From: Martyn White <Martyn.White@arun.gov.uk> **On Behalf Of** Conservation Officer
Sent: 22 July 2026 13:46
To: Planning.Responses <Planning.Responses@arun.gov.uk>
Cc: Jonny Cooper <Jonny.Cooper@arun.gov.uk>
Subject: EP/55/26/HH

EP/55/26/HH

Address: Vista Point 21 Tamarisk Way East Preston BN16 2TE

Proposal: Replacement of first floor rear glazing.

DRAWING
EXISTING AND PROPOSED GLAZING
ELEMENT W.5

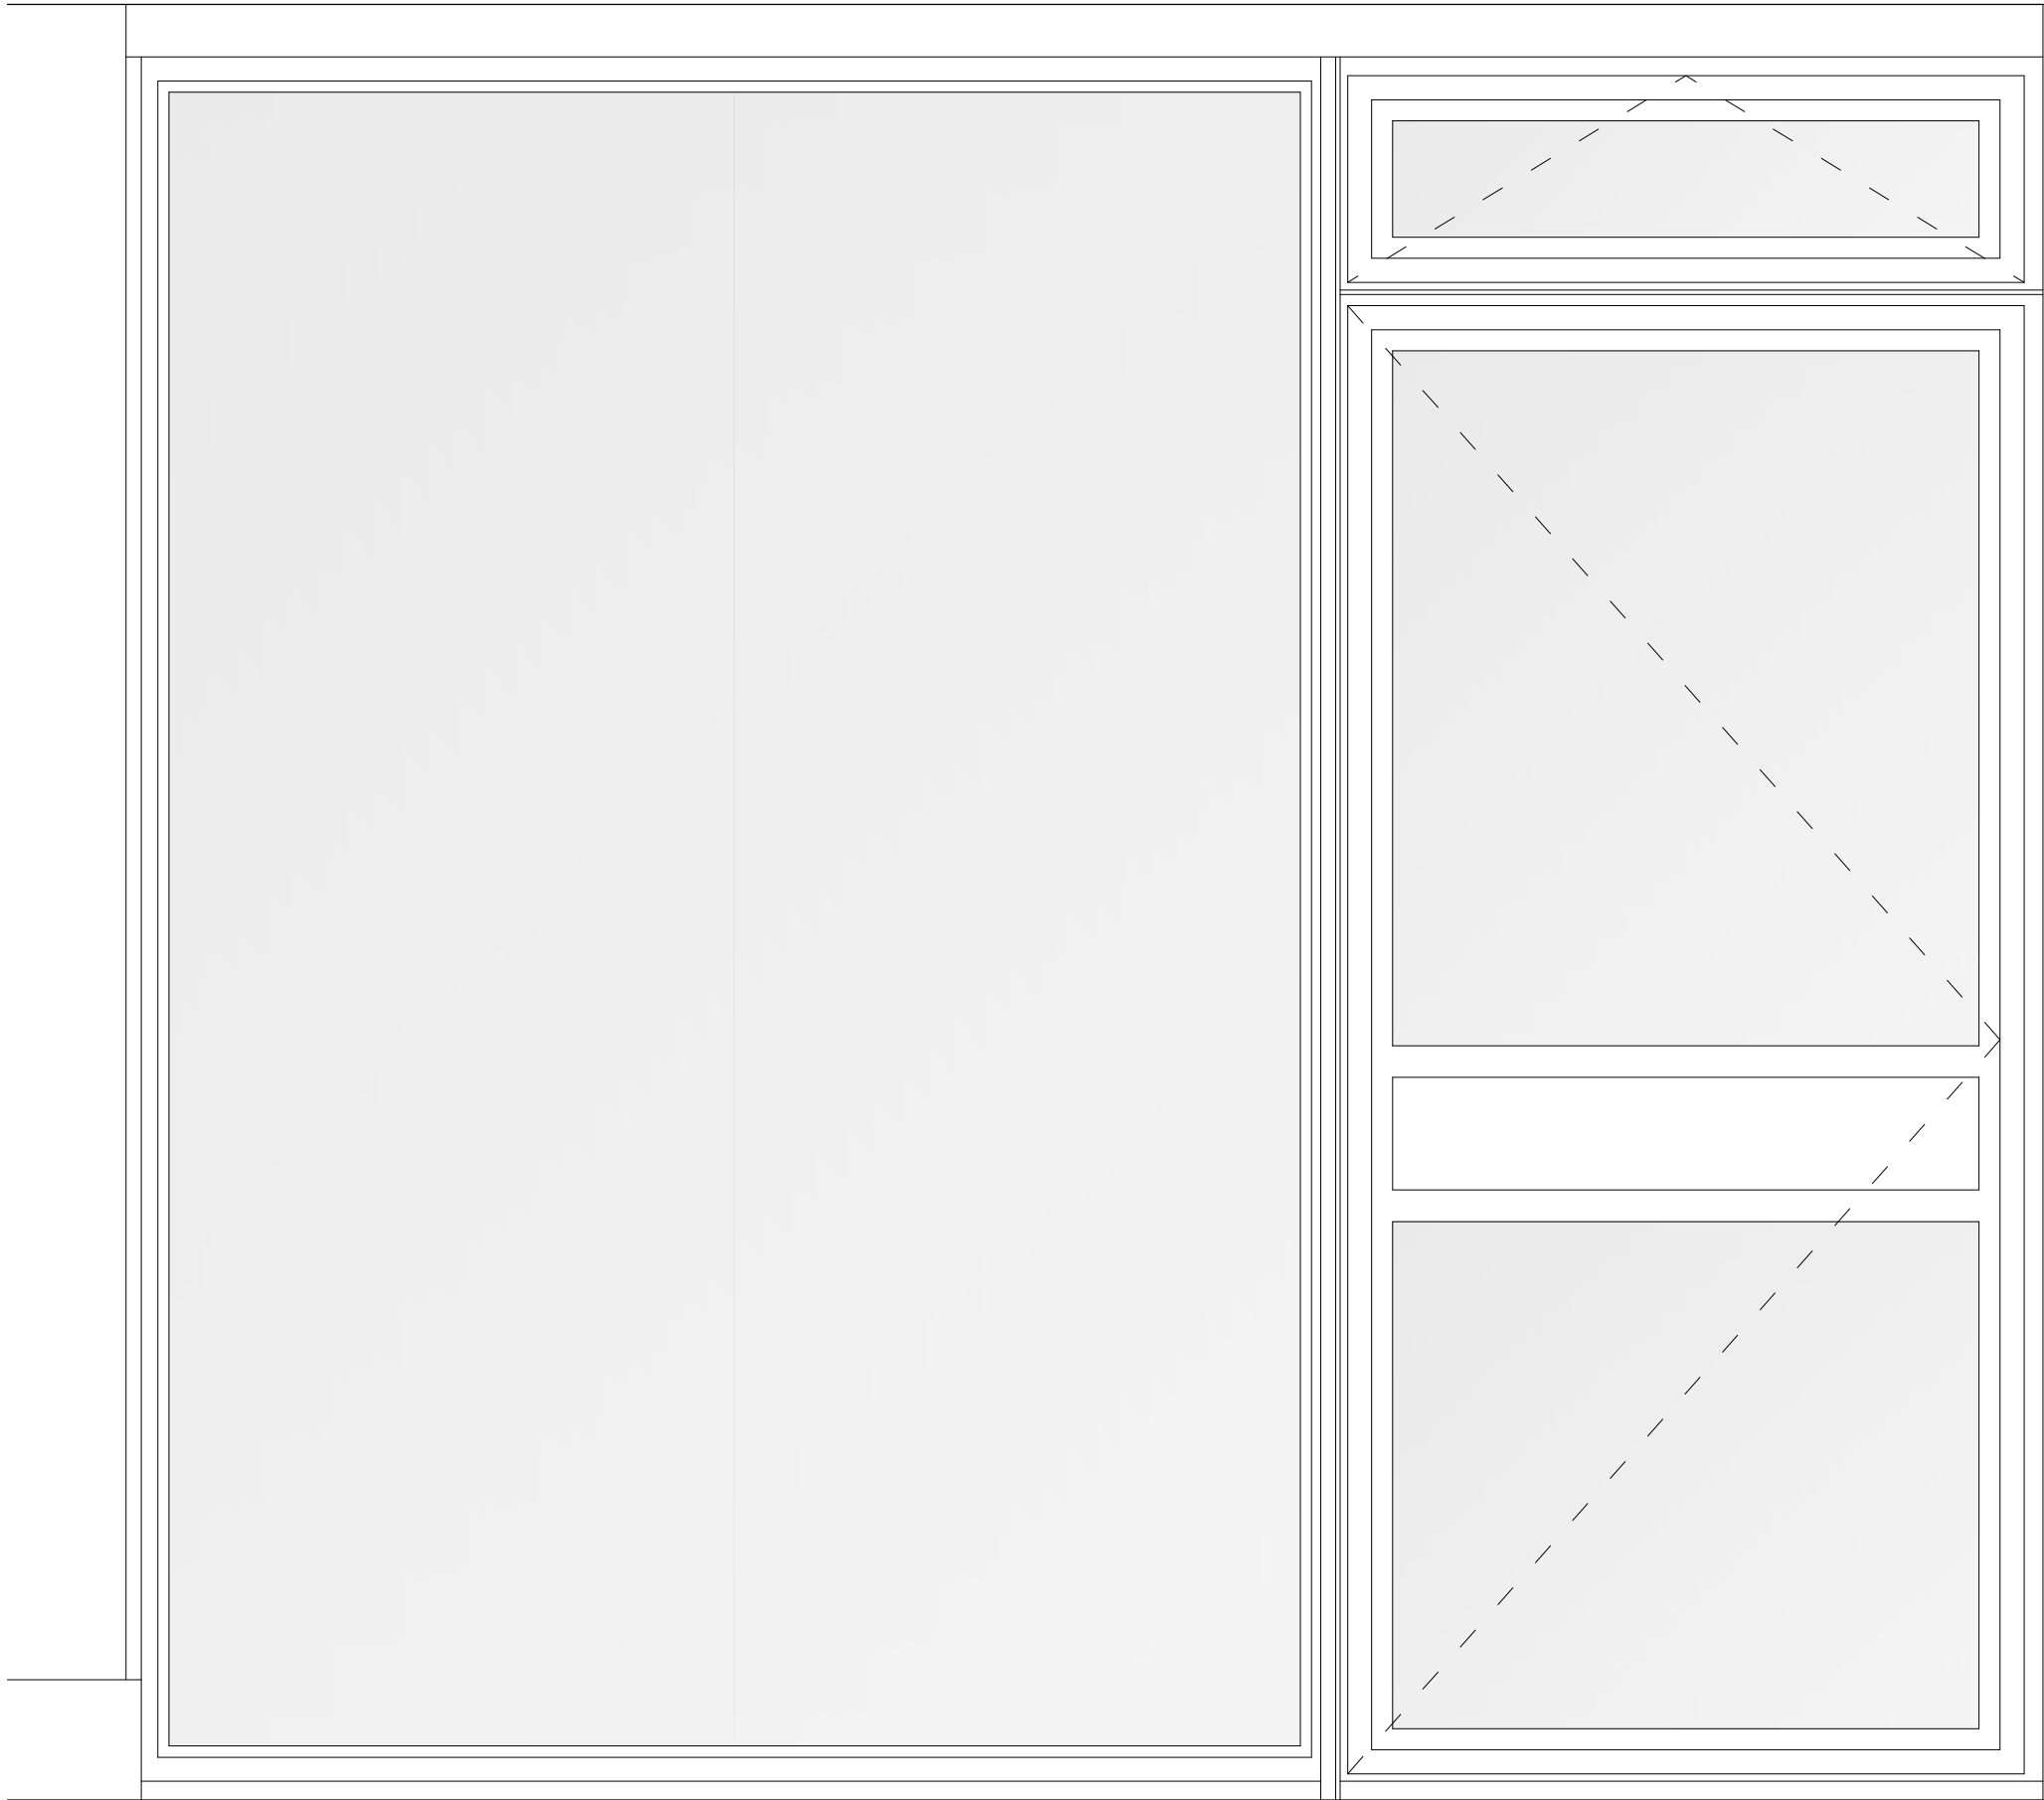
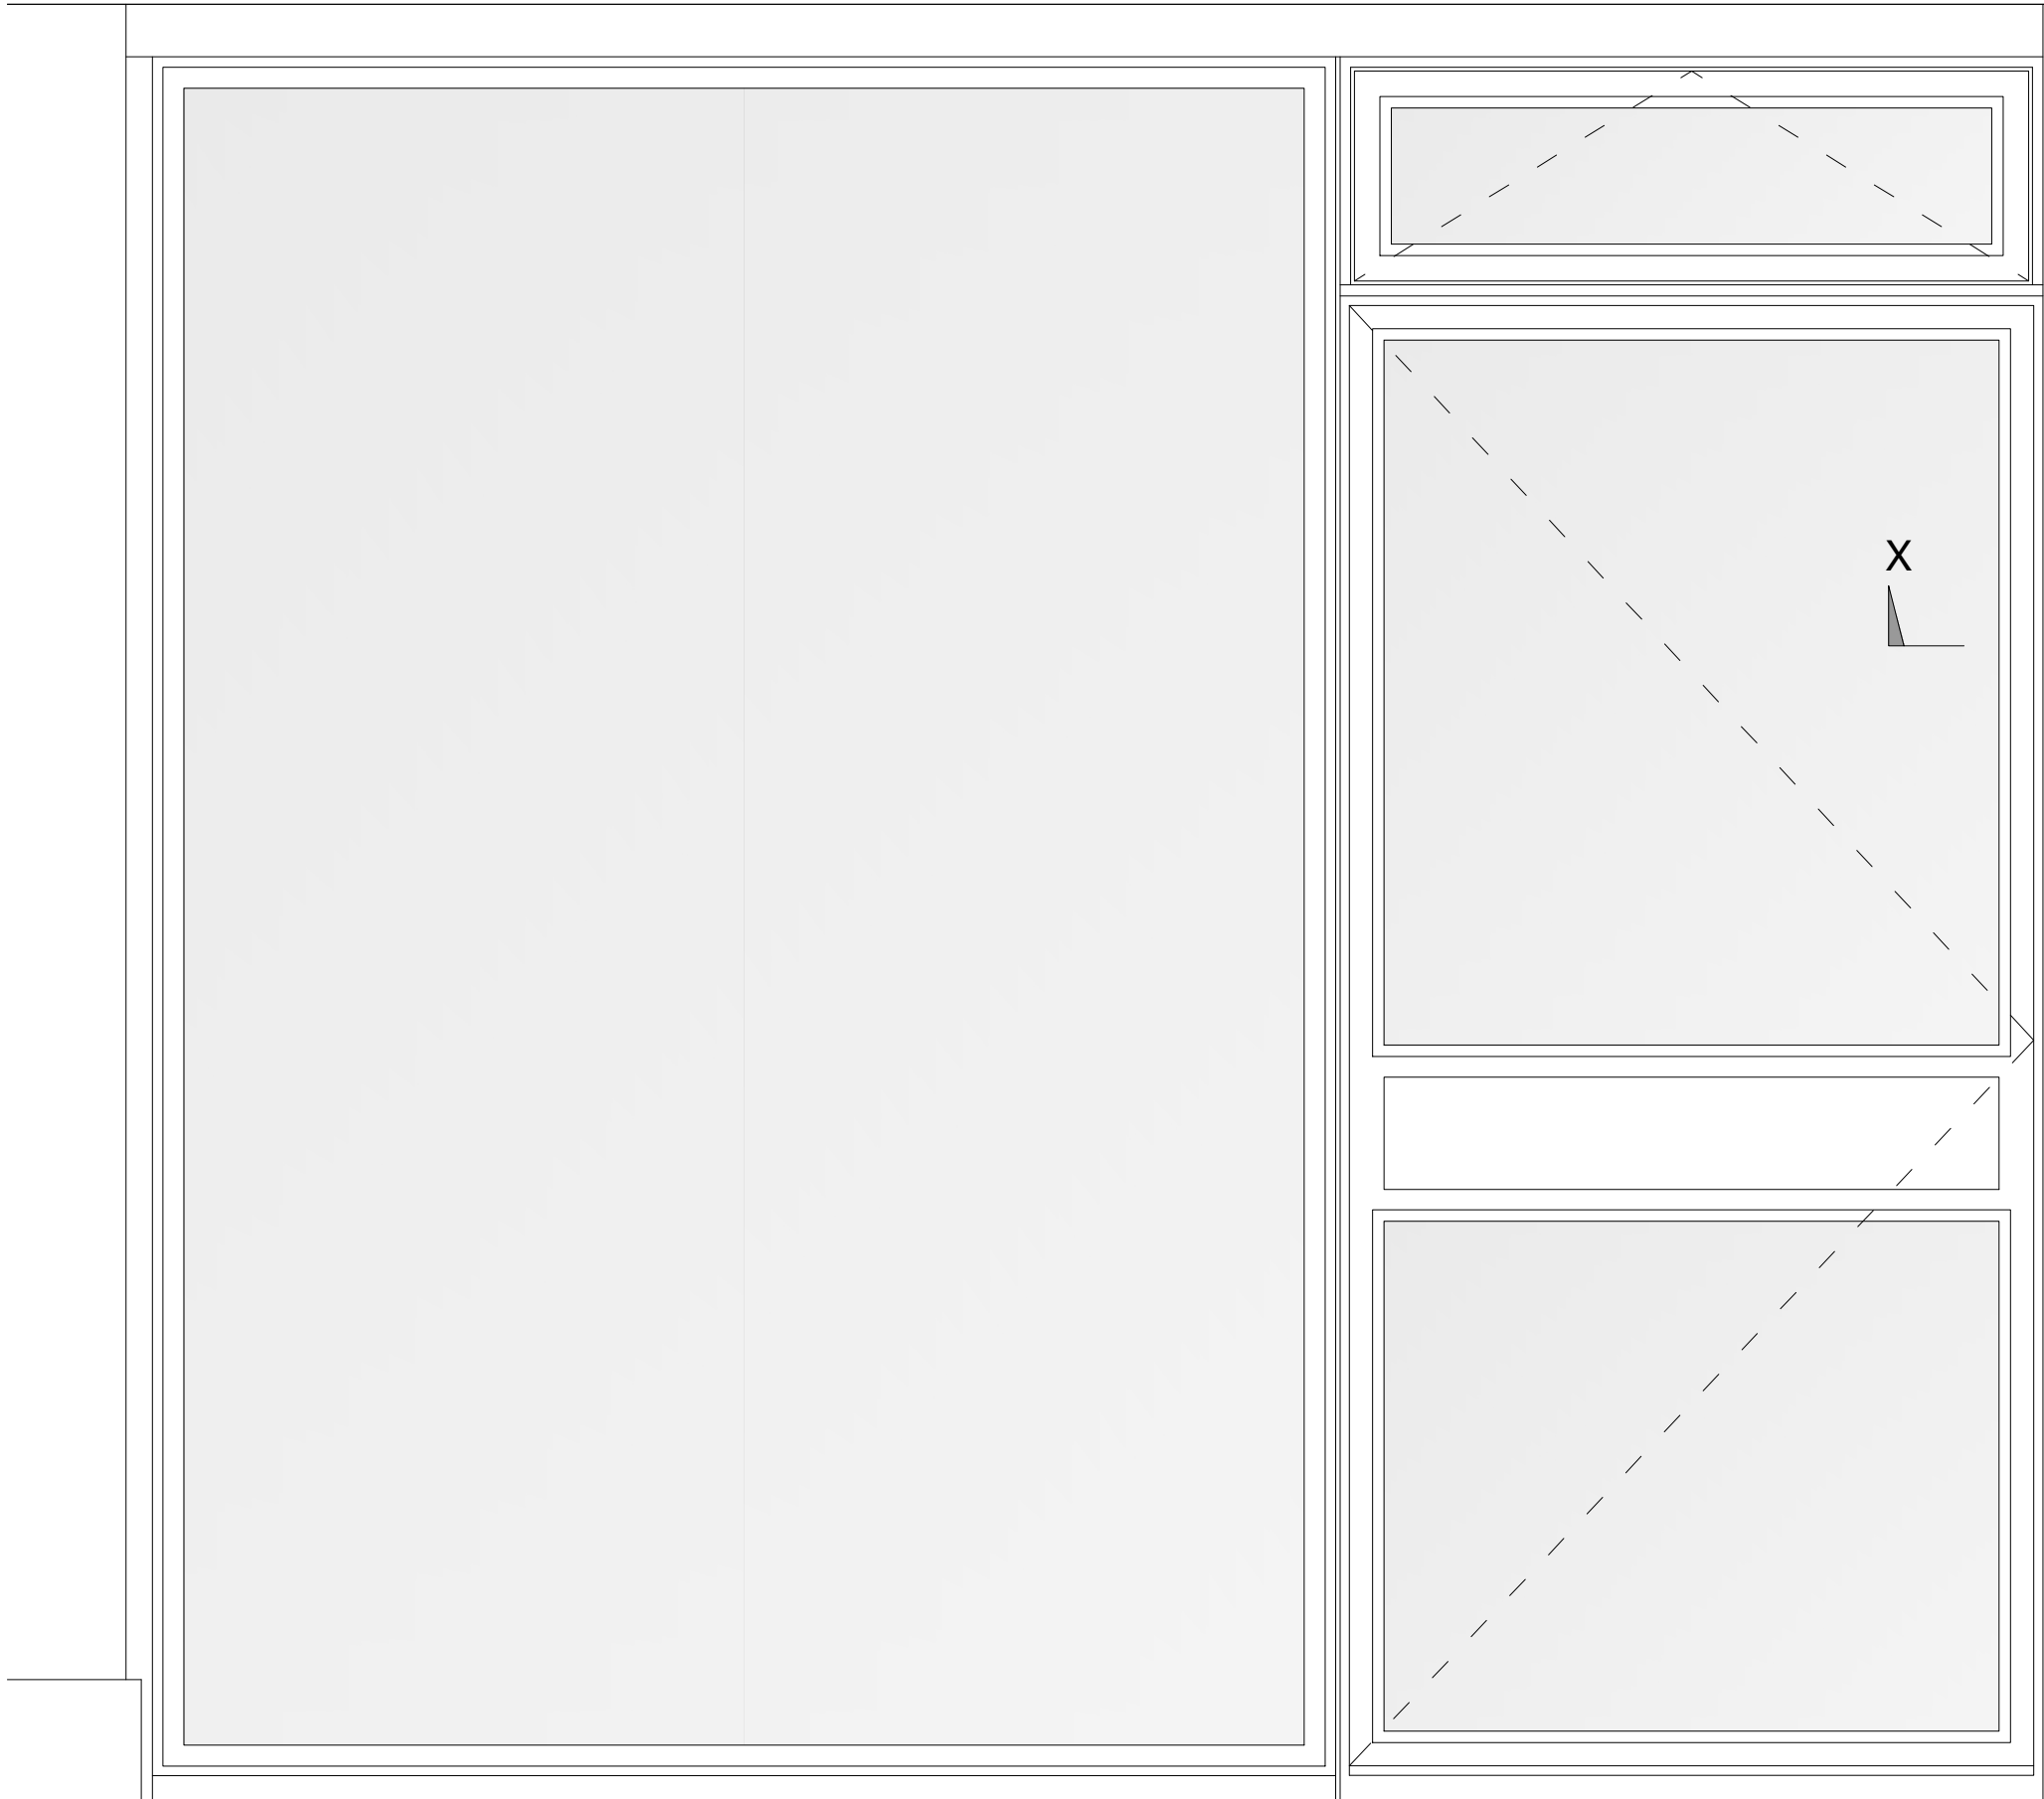
The general approach to the replacement of the windows is positive. However, I have one concern. Whilst the proposed arrangements for windows W3 and W5 seek to replicate the existing design, they do not appear to accurately reproduce the existing glazing proportions. In particular, the vertical frame sections associated with the fanlight and the casement below do not appear to be of a consistent width when compared with the existing arrangement, resulting in a subtle alteration to the sightlines and visual balance of the glazed openings. As the proposed arrangement for W2 appears to more closely replicate the existing sightlines, the applicant should clarify whether the framing sections to W3 and W5 can be adjusted to more closely reflect the existing arrangement.

Further clarification is required regarding the details of the two windows before I can conclude a level of harm.
